CLOL OBJECTION

SSD-14394209 – AMENDMENT Sept 2022

BUNGENDORE HIGH SCHOOL Project

Figure 1.1 Proposed site plan

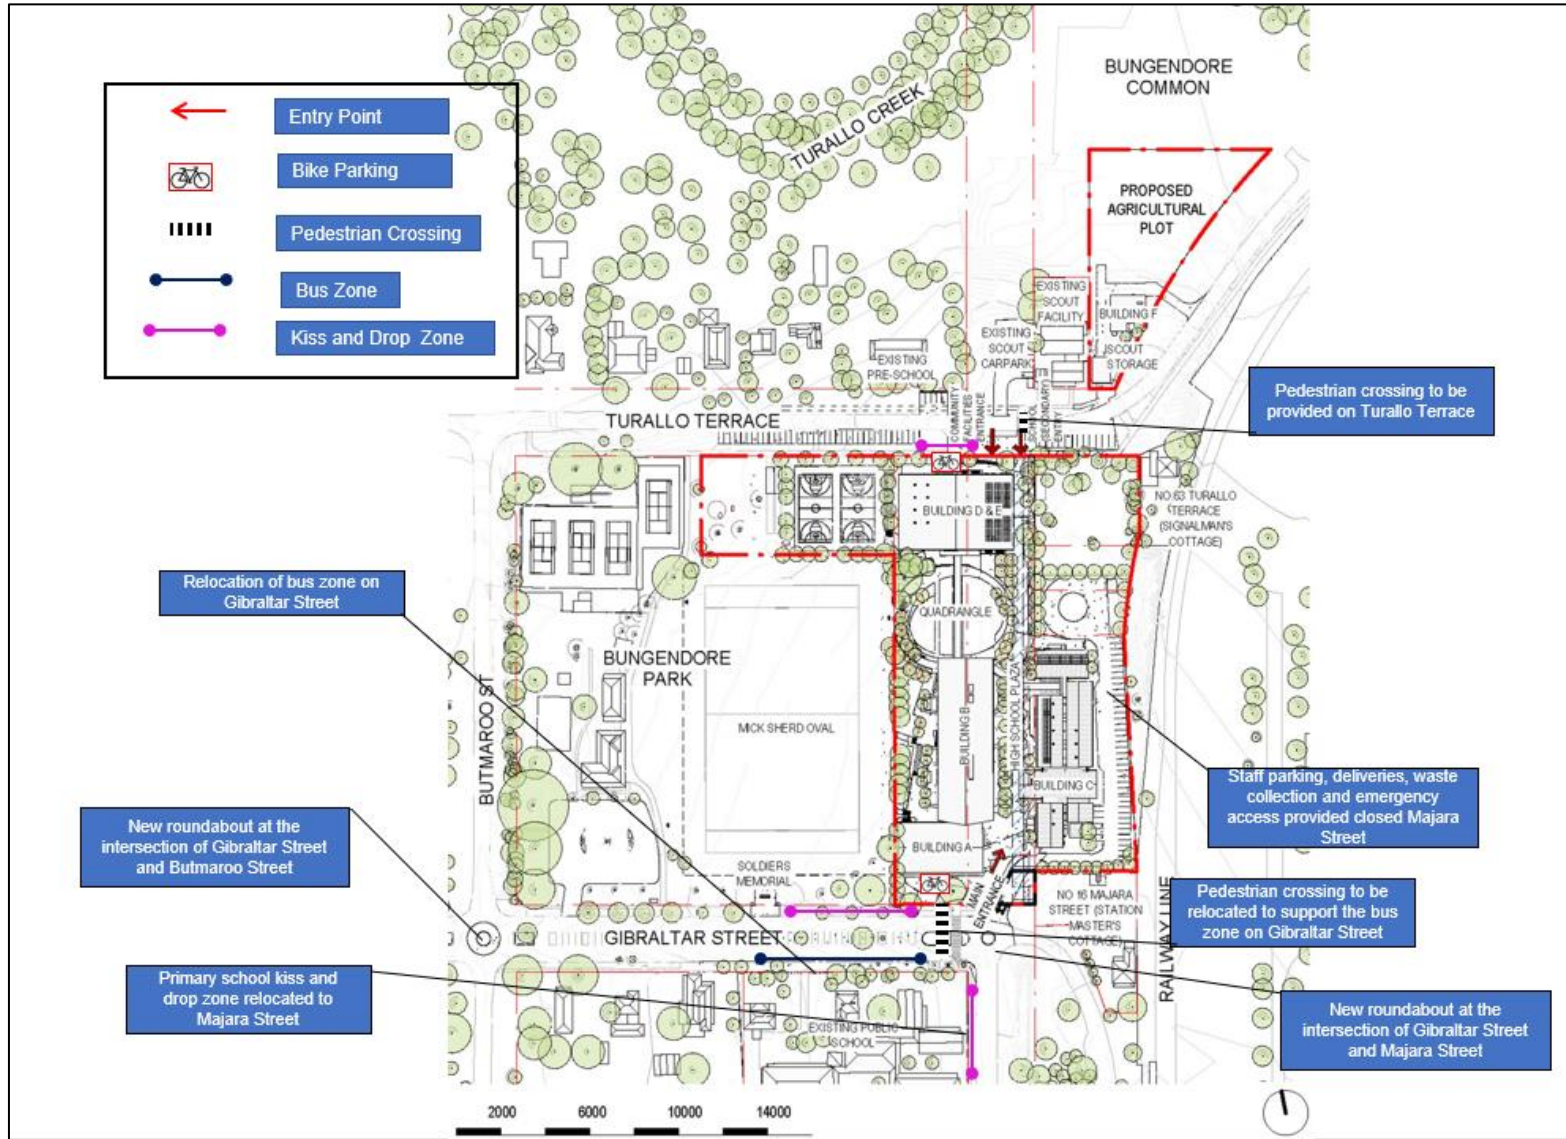
With BHS added, it's not only going to DOUBLE student numbers – there'll be 58 fewer carpark spaces and even LESS road space than there is now, just by closing that whole Park-side stretch of Majara. But it gets worse – the Amendment shows a whole new, larger roundabout, taking more park spaces, and with one exit being straight into the school main entry – not good traffic planning just for a start.

But look at the site plan. See the way it's an L-shape, linking Gibraltar to Majara southwards – and no other way in or out. But this is the access way that a fleet of school buses will have to navigate along with cars. .

The neat drawings of tidy cars that appear in the Amendment don't even come close to explaining how this reduced roadway will operate when such a confined area has to cope with the combined convergence of 1000 students – and anything up to 500 cars
